DEPARTMENT OF PUBLIC WORKS

RE: Hyak PUD Addendum

Public Works has reviewed the additional materials provided by the applicant (Hyak PUD) and our comments appear below for your consideration.

**DEVELOPMENT, STORMWATER AND
 PARKING PLAN - PARCEL D**

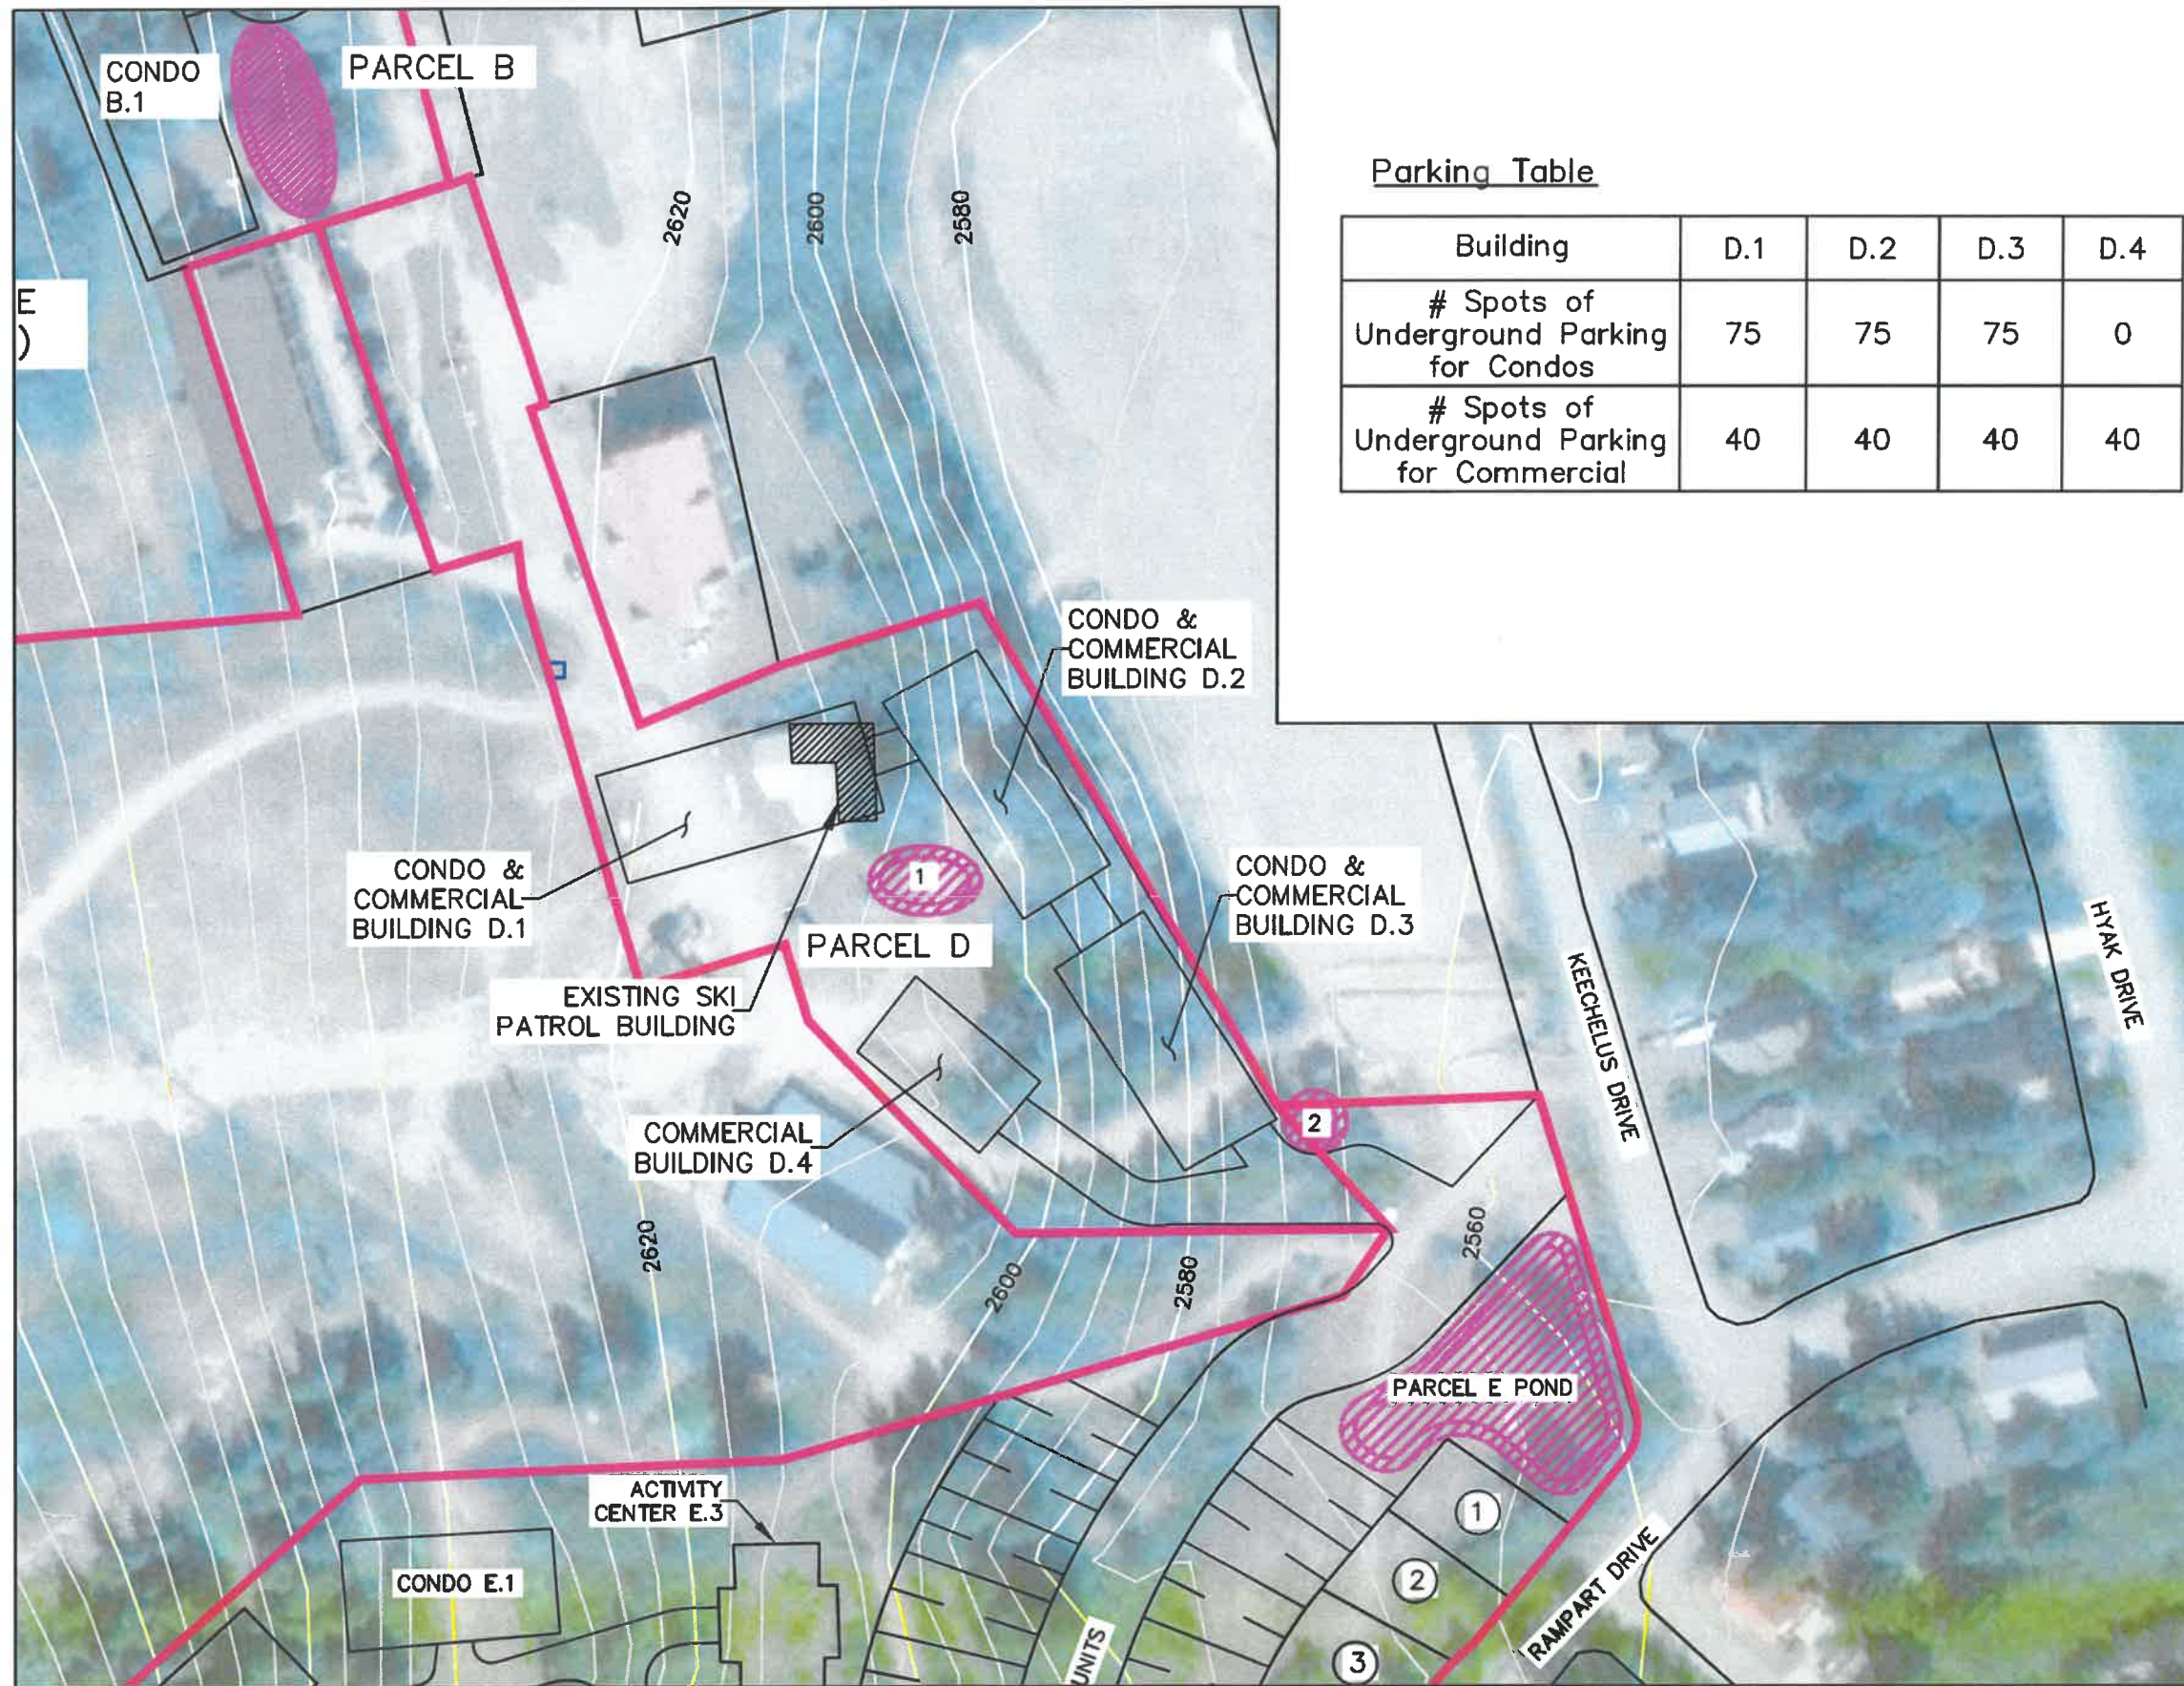
1. Several of the proposed stormwater ponds appear to span multiple contour intervals. The contour interval appears to be five feet. Please be advised that constructing the proposed ponds will likely impact developable land in the vicinity of the ponds. Public Works will assess the viability of pond construction on hill side slope at the time of civil engineering design submittal.

HYAK SNOW STORAGE EXHIBIT

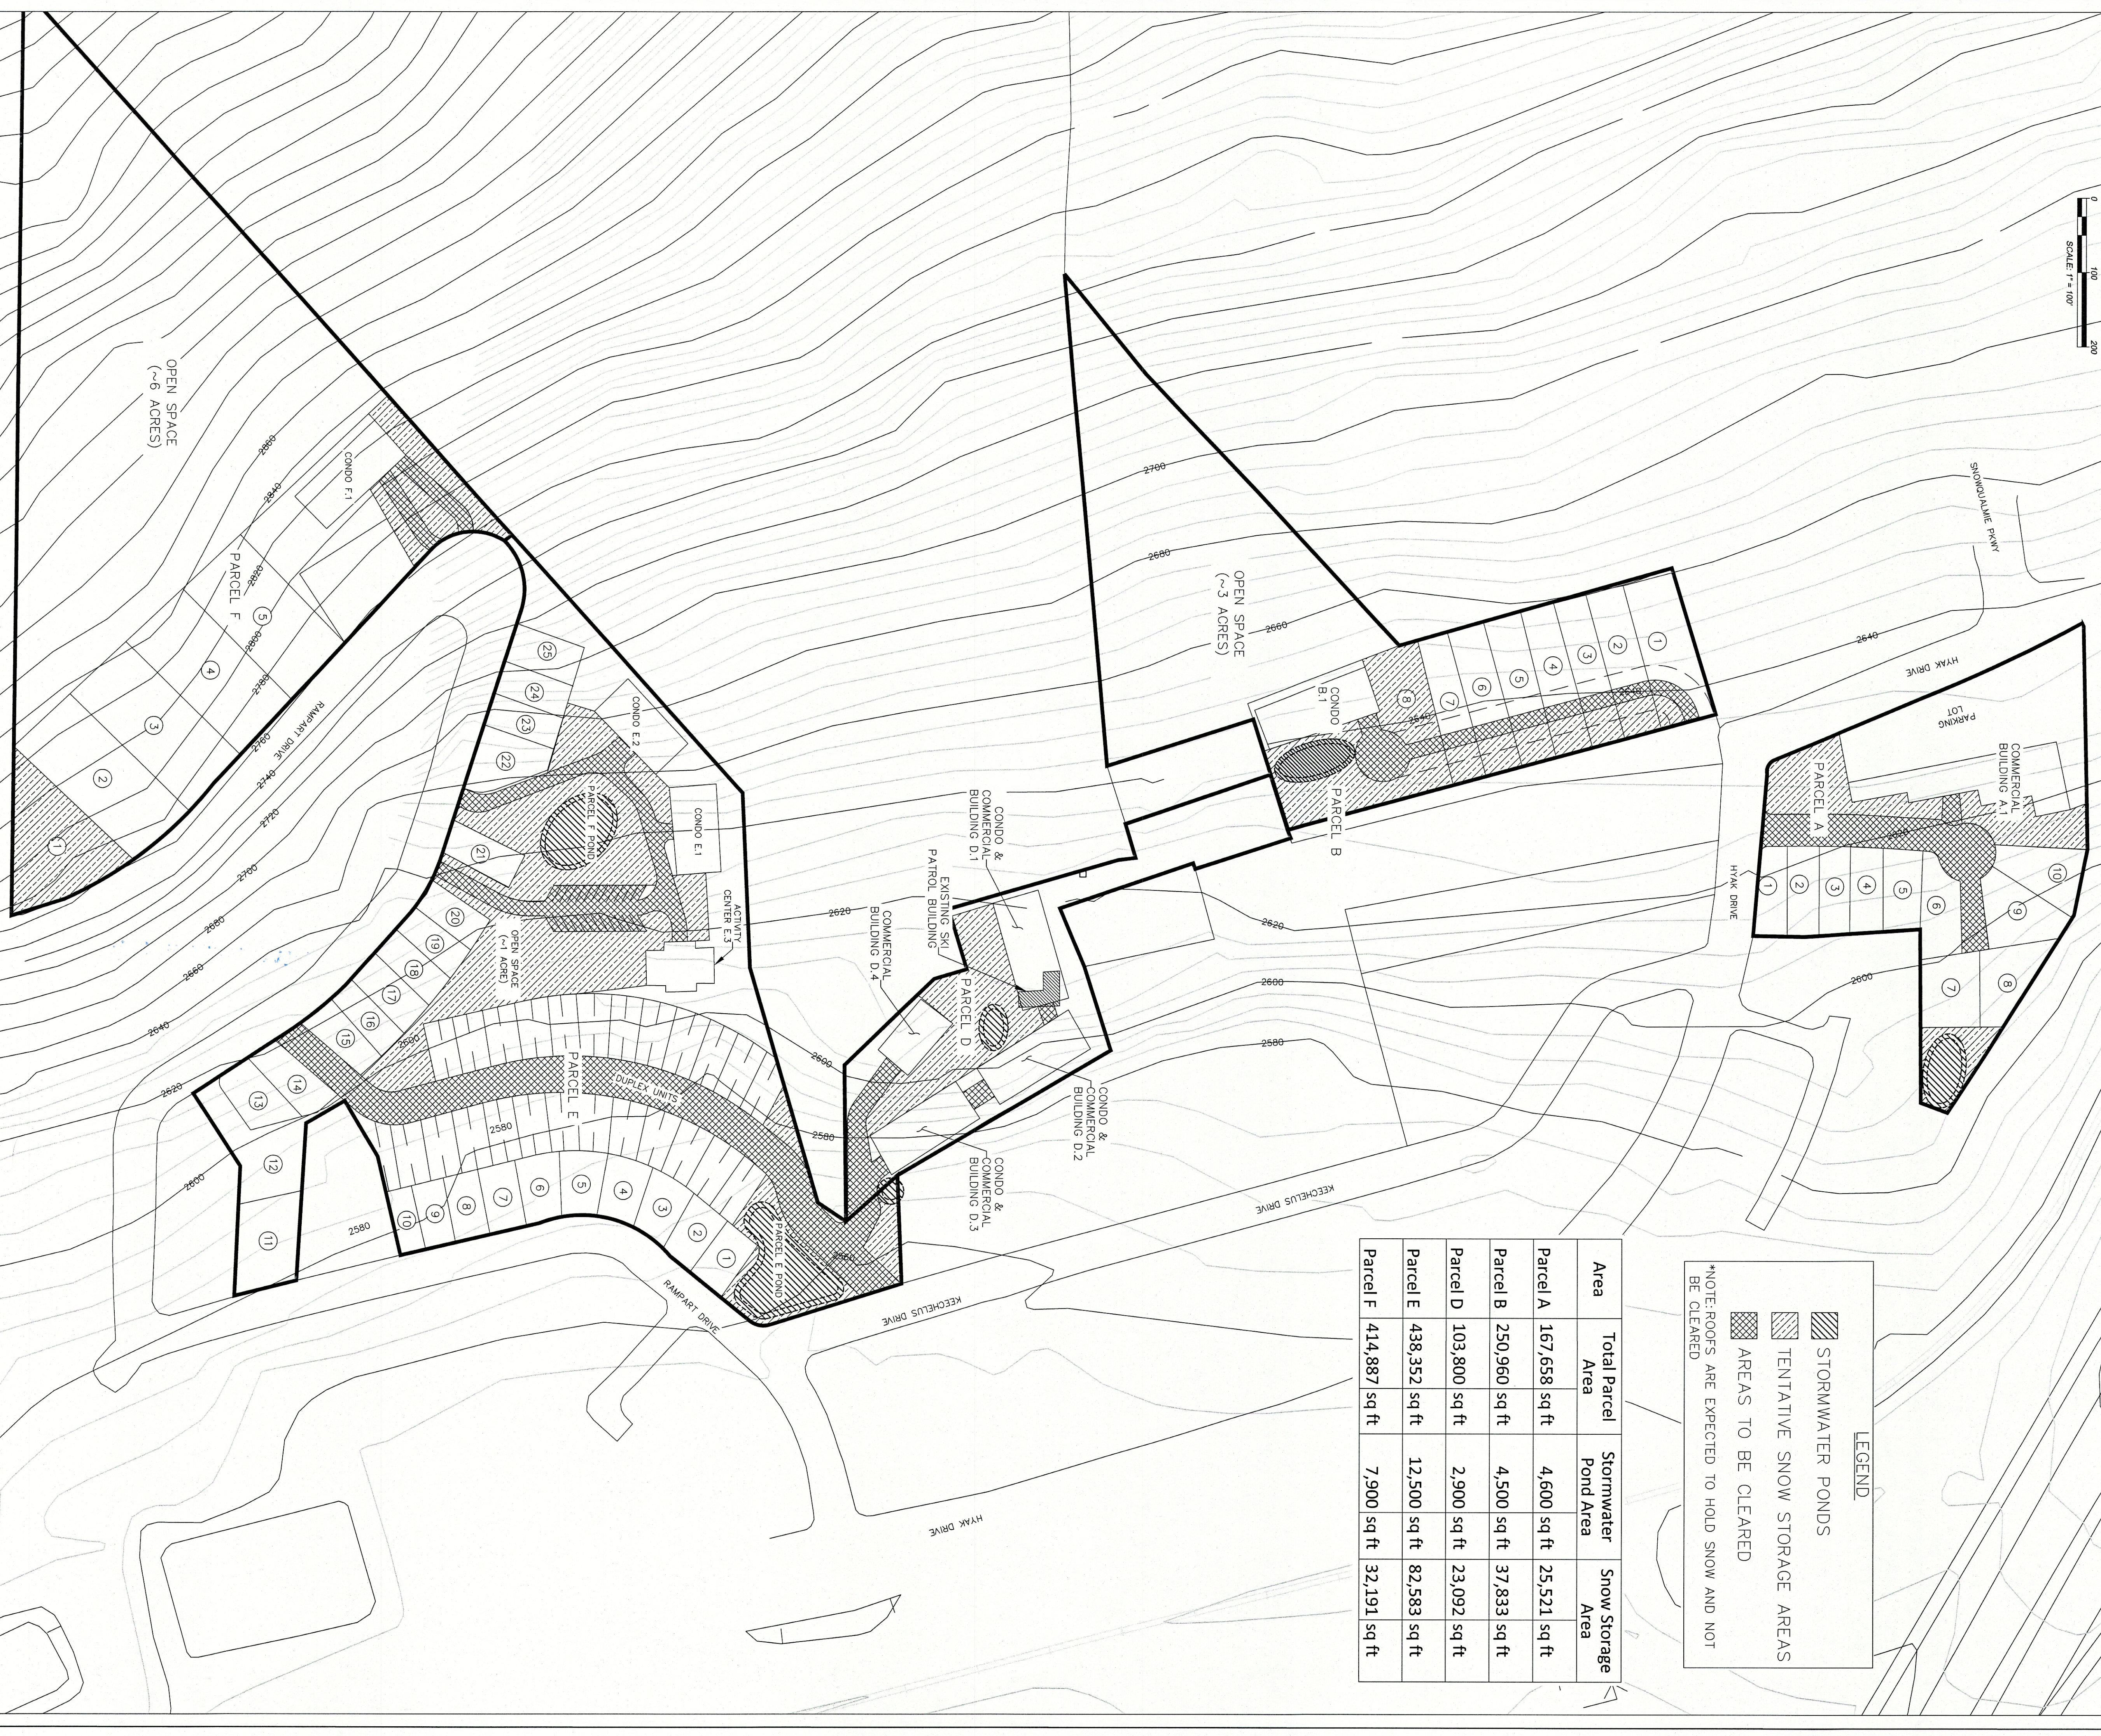
2. Proposed snow storage appears to be associated with new roadway construction, with the exception of Parcel F. If the extension of Rampart Drive is proposed to be constructed as a public roadway, the loss of downgradient parcels for snow storage will likely necessitate our petitioning the Board of County Commissioners for removing Rampart Drive from the public road network. The loss of snow storage could easily force Public Works to truck snow from Rampart Drive. We have been communicating our declining ability managing snow removal in Hyak as lots continue developing in the area. The applicant is encouraged to develop snow storage areas knowing the increasing likelihood of eventual county abandonment and reliance on private snow removal service providers.
